110 O'CONNOR

REDEVELOPMENT PROJECT MIXED-USE BUILDING

SITE PLAN APPLICATION

OCTOBER 2025

1
A-200
ÉLÉVATION NORD
1 : 150

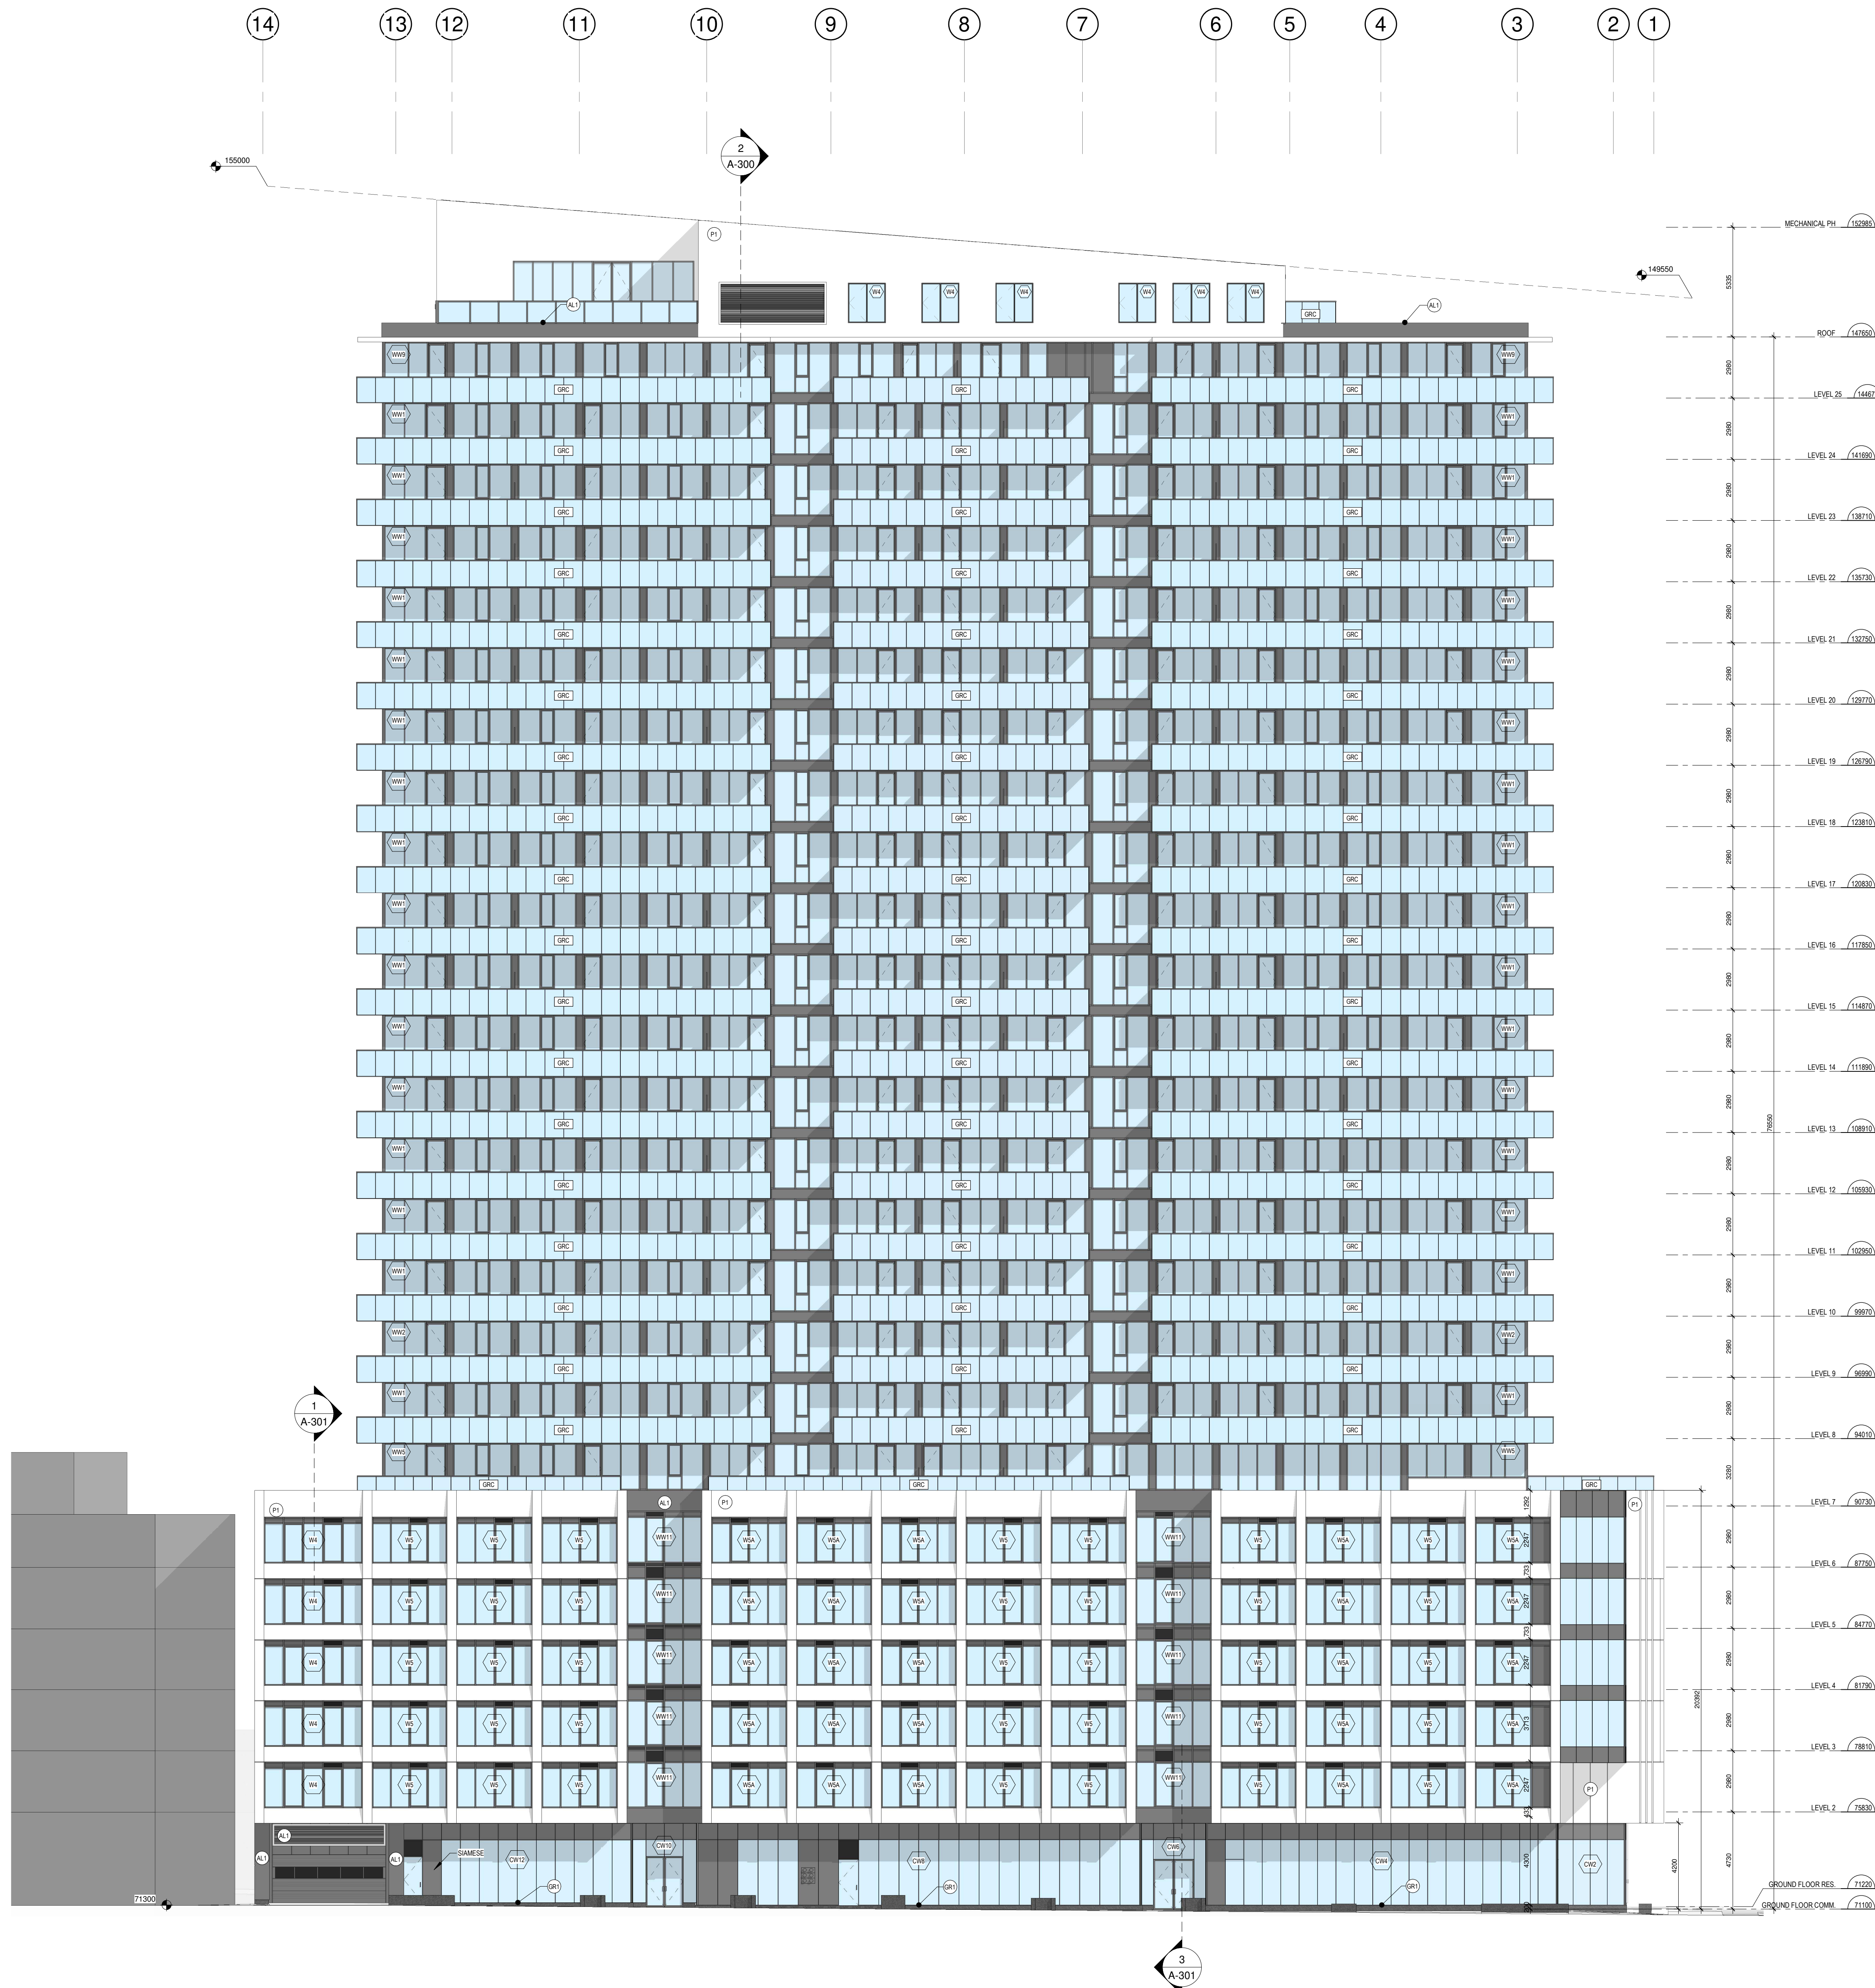
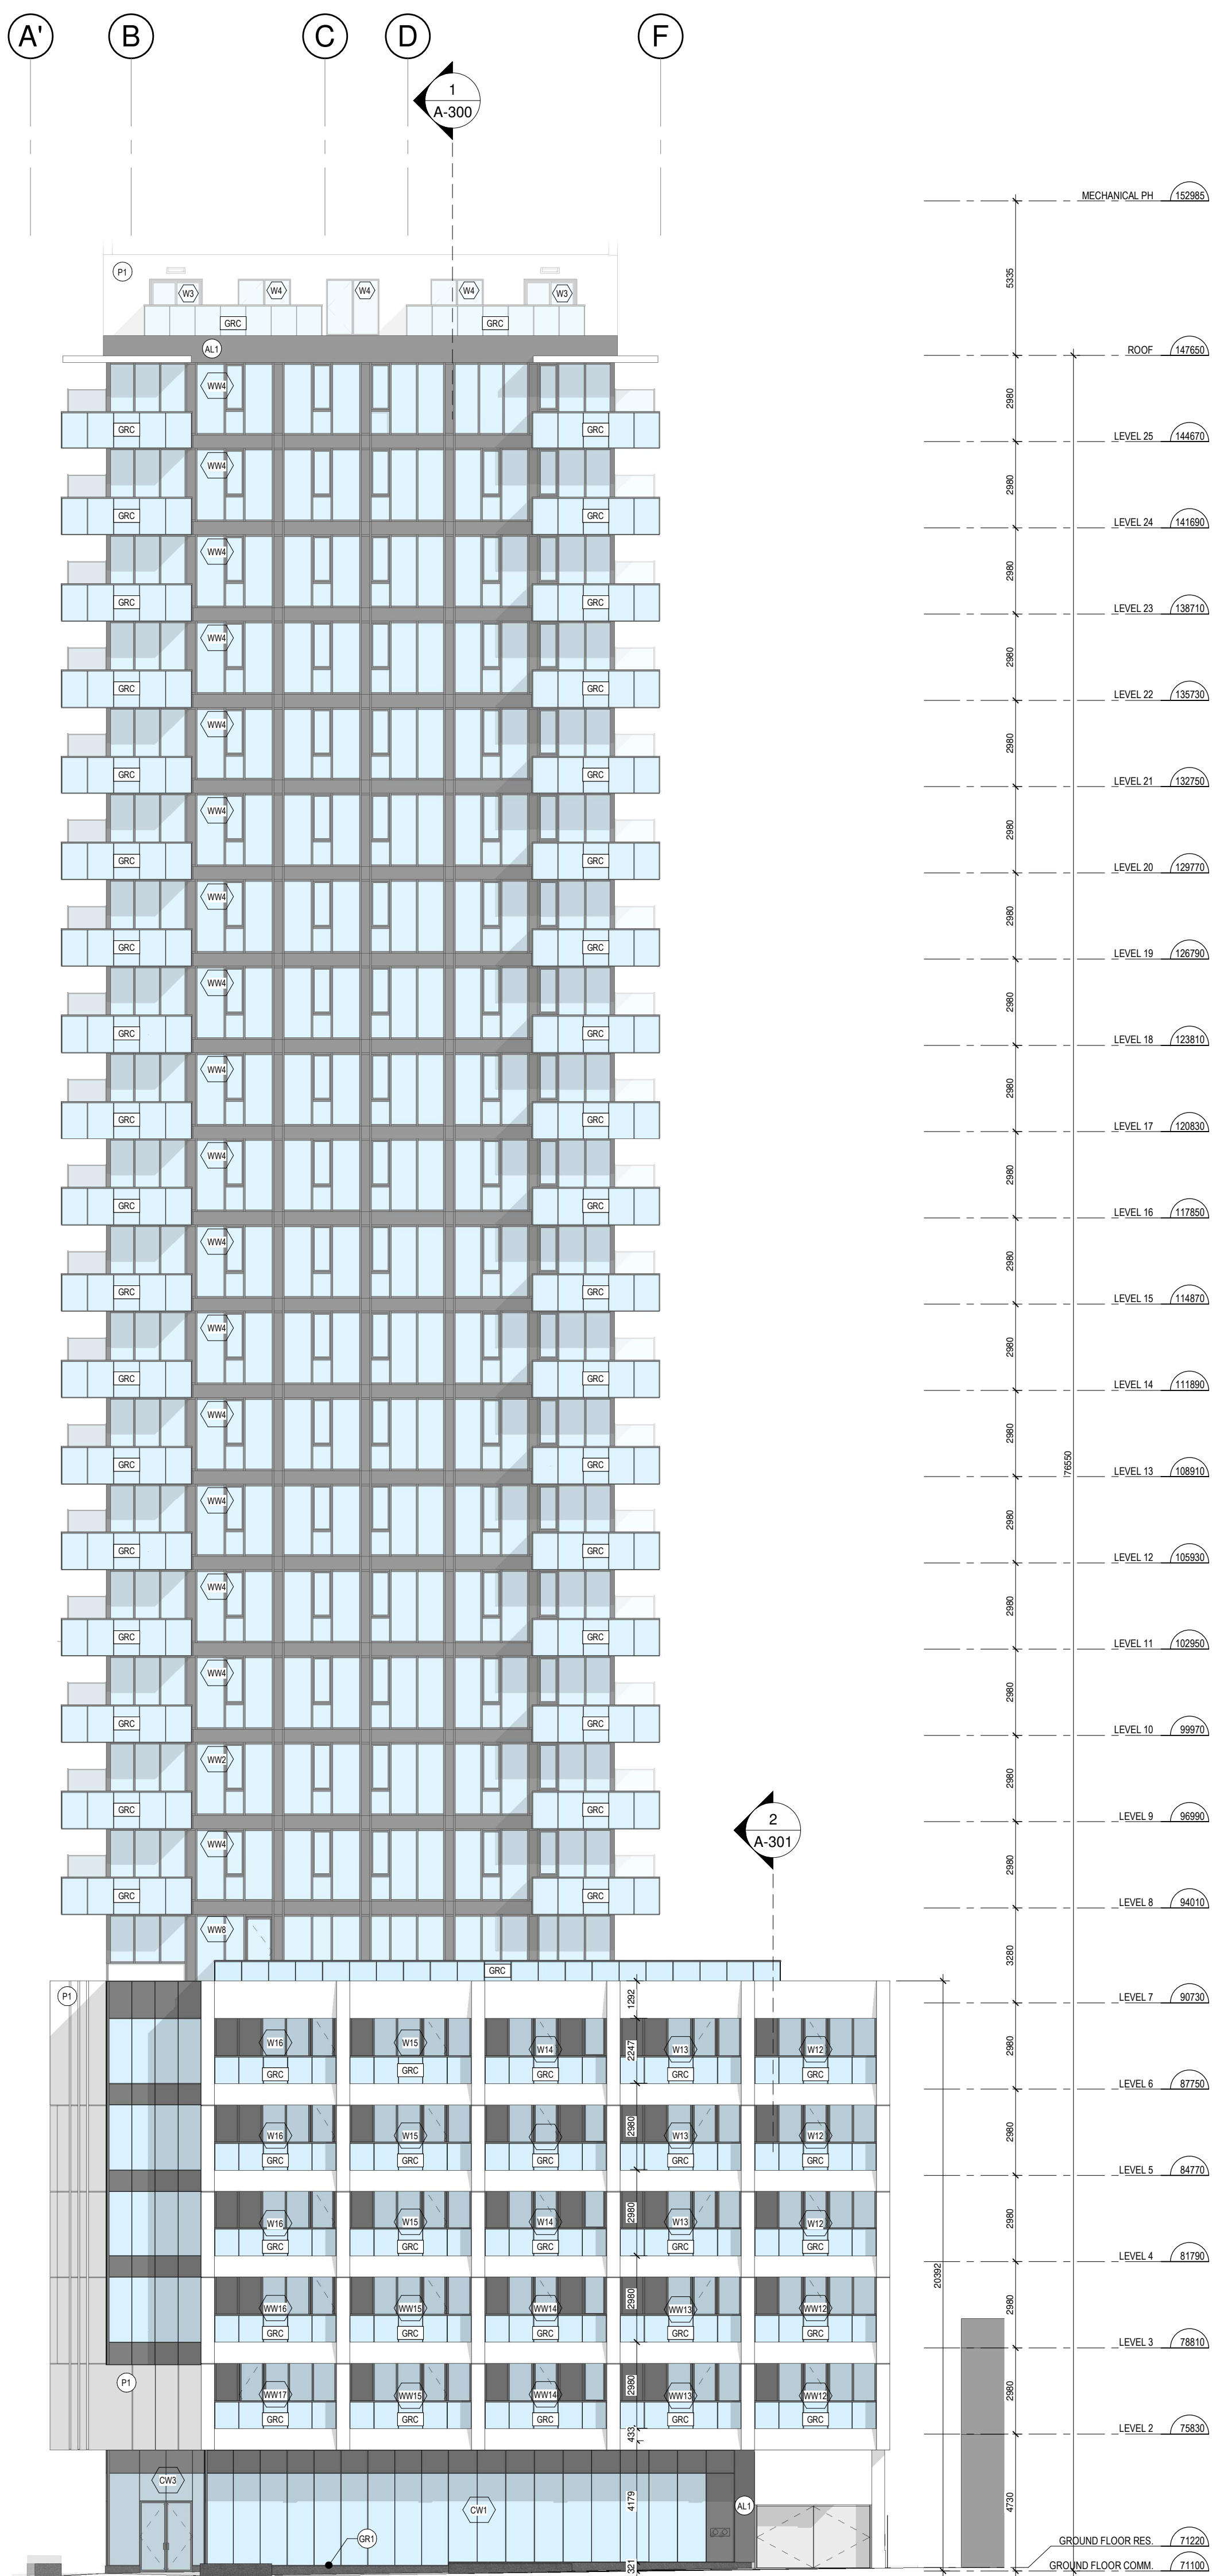
Reduce the height of the podium. The height and the articulation of the podium should take into consideration the width of the public streets, which are approximately 20m, and the heritage building at 124 O'Connor. A 6-storey podium would be more appropriate with respect to street proportion and relationship with the heritage building next door.

The facade of the podium should be responsive to the context, particularly to the heritage building at 124 O'Connor.

The podium height has been reduced to six (6) storeys.

Homage is paid to 124 O'Connor with the re-interpretation of the three recessed linear elements on its facade.
